Response to submissions

St Peters concrete plant and materials handling facility - Modification 11

Prepared for Boral Resources (NSW) Pty Limited | 11 September 2018

Response to submissions
Modification 11
Boral St Peters
Figure 3.1 A

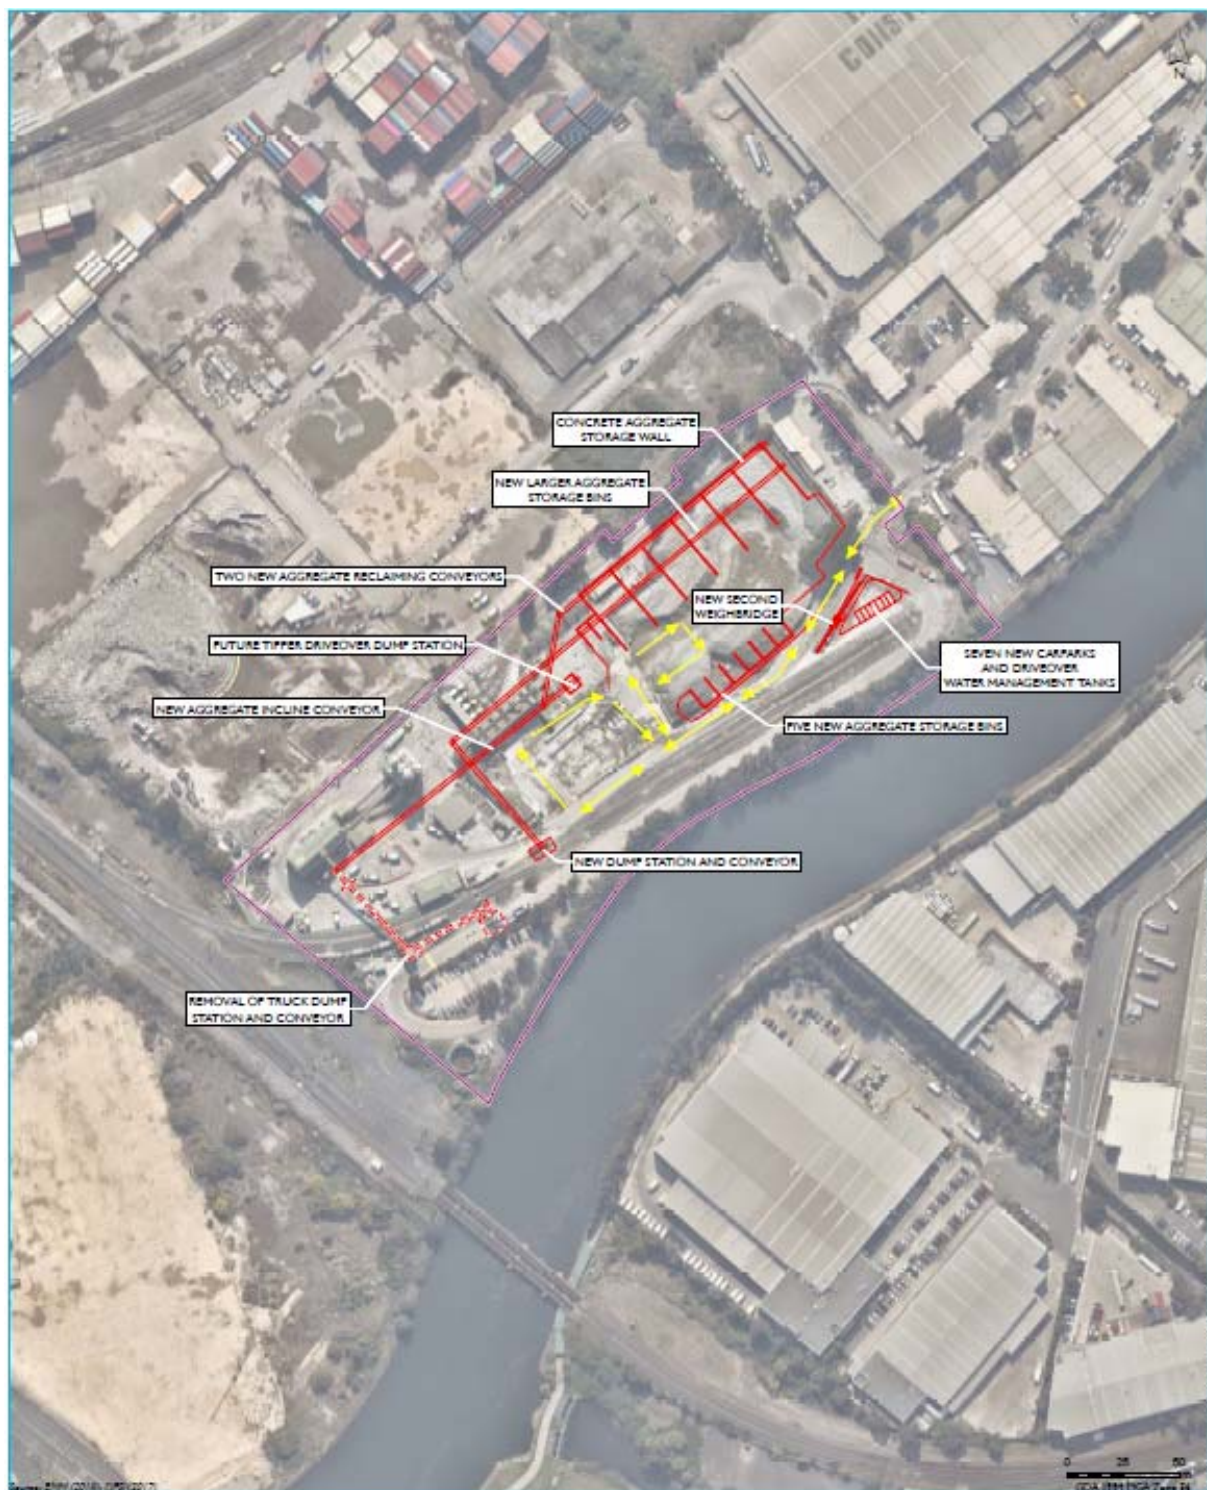
DPE asks for further clarification with respect to the number of additional slump stands. Section 3.3 of the St Peters Mod 11 EA states there are two additional stands, however, Figure 3.1 appears to show three additional stands.

The reference to two additional stands in Section 3.3 of the St Peters Mod 11 EA was a typographical error. Boral confirms that there will be three additional double position slump stands as outlined in Section 3.1.
